WEST SUSSEX COUNTY COUNCIL CONSULTATION

TO:	Arun District Council FAO: Simon Davis
FROM:	WSCC - Highways Authority
DATE:	5 August 2020
LOCATION:	Byfields and Nightingale Cottages, Nyton Road, Westergate, PO20 3US
SUBJECT:	AL/49/20/PL Demolition of 2 No existing dwellings & erection of 7 No. dwellings (1 being the replacement of Nightingale Cottage) with associated parking, bin store, alterations to the existing access & extension of the existing footway. This application part affects the setting of a Grade II Listed Building.
DATE OF SITE VISIT:	N/A
RECOMMENDATION:	More Information
S106 CONTRIBUTION TOTAL:	N/A

ACCESS DESIGN:

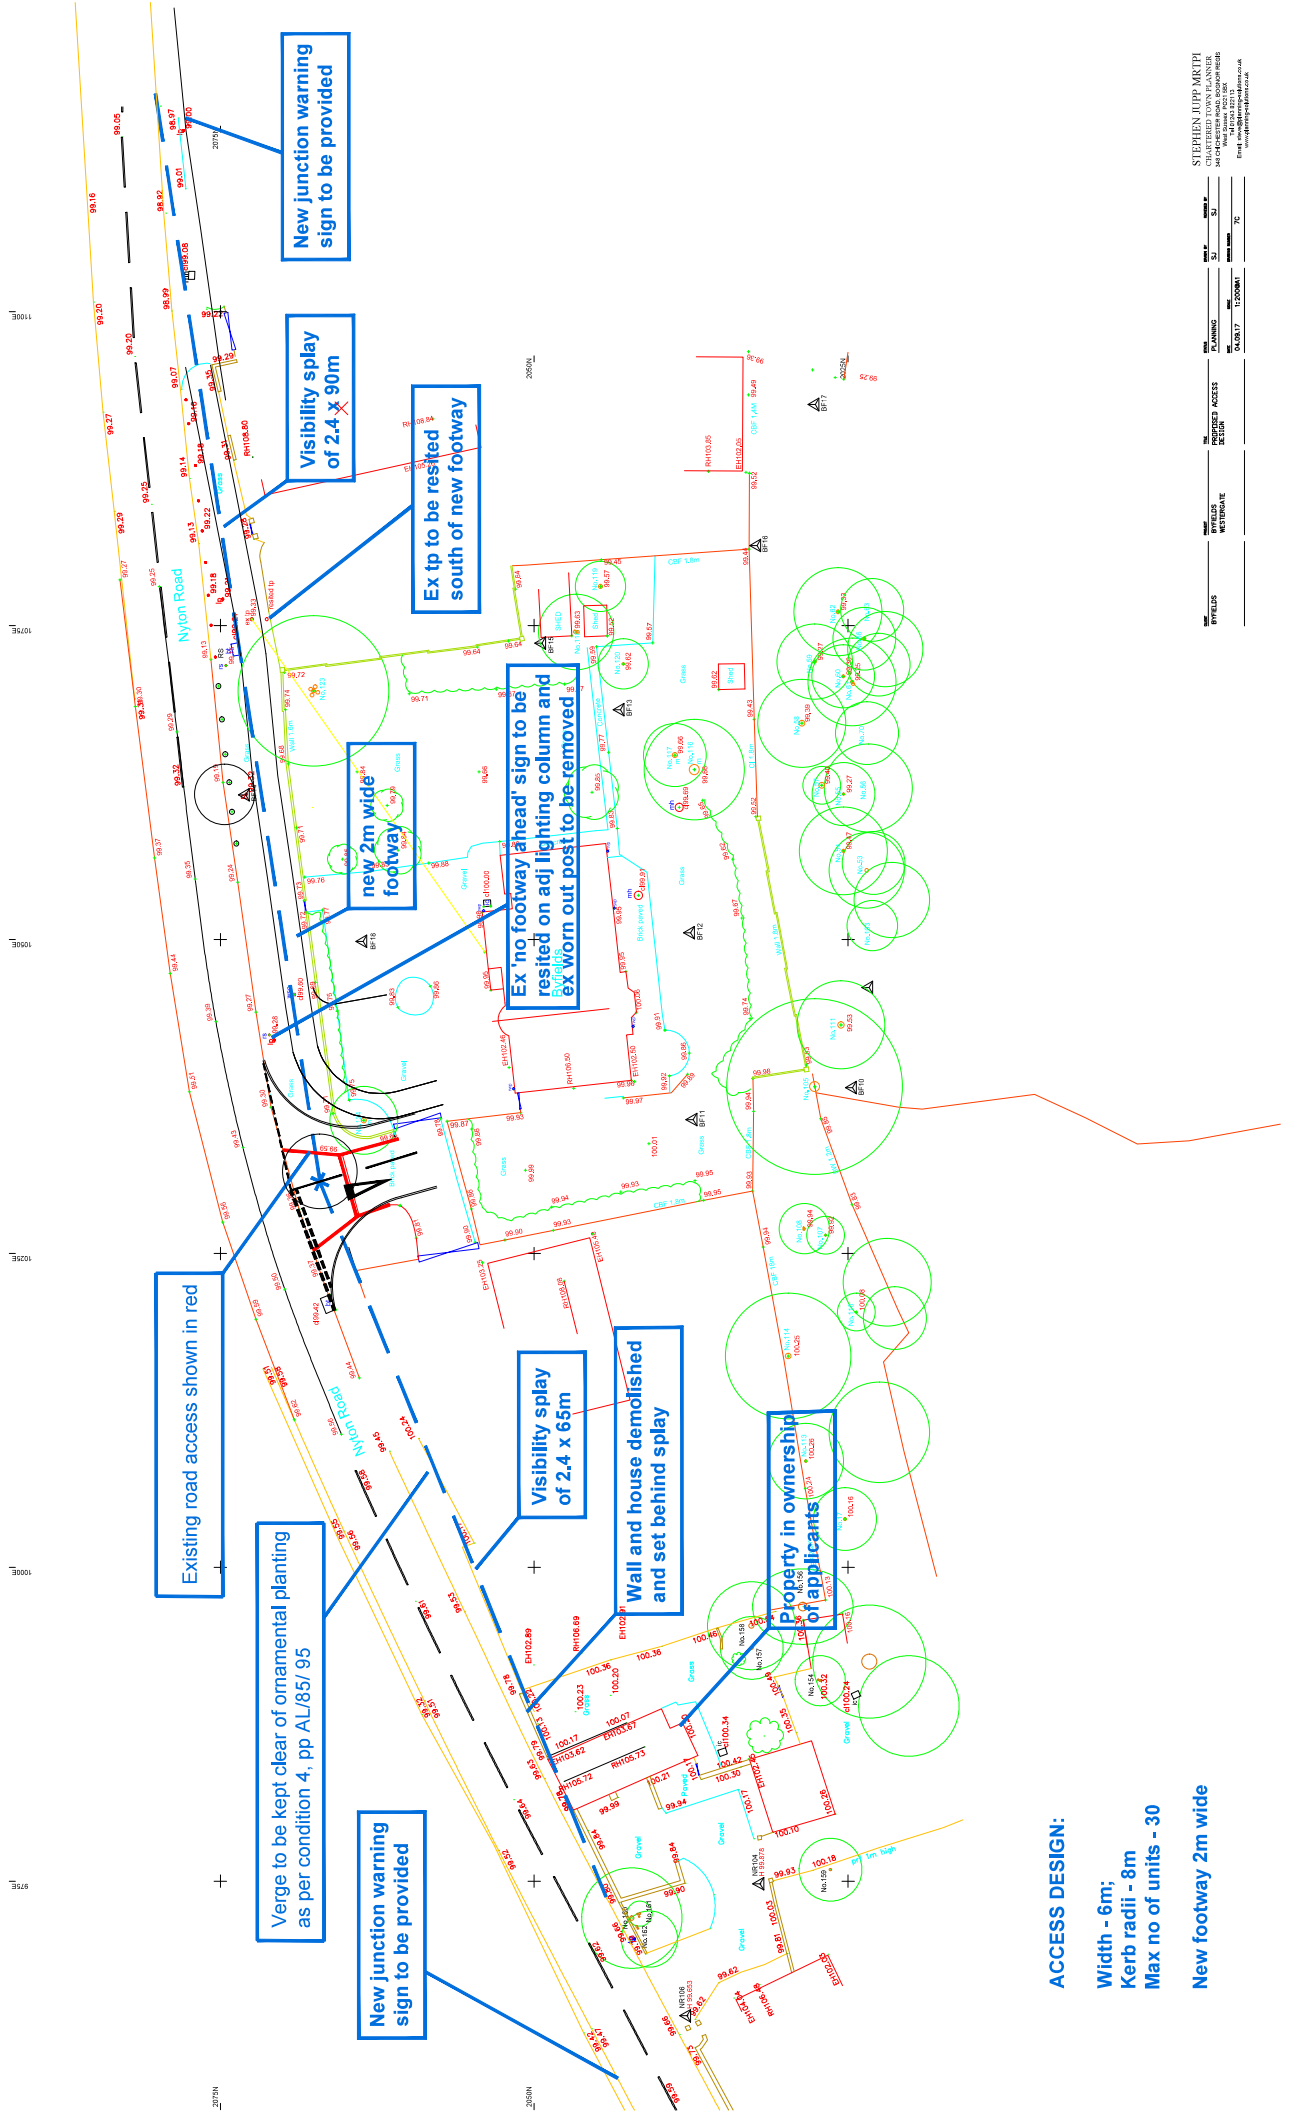
The applicant proposes a modification of the existing access, incorporating a 6m wide bellmouth with 8m kerb radii. The applicant has demonstrated vehicular visibility splays at this access, with splays of 2.4m x 65m to the west and 2.4m x 90m to the east. These splays are supported by seven-day speed survey data.

However, the western visibility splay appears to cross third party land. As such, this splay cannot be secured in perpetuity. How does the applicant propose to secure visibility at the access? The visibility splays must intersect land only within control of the applicant or within the publicly maintained highway and must be drawn to the nearside edge of the carriageway in both directions.
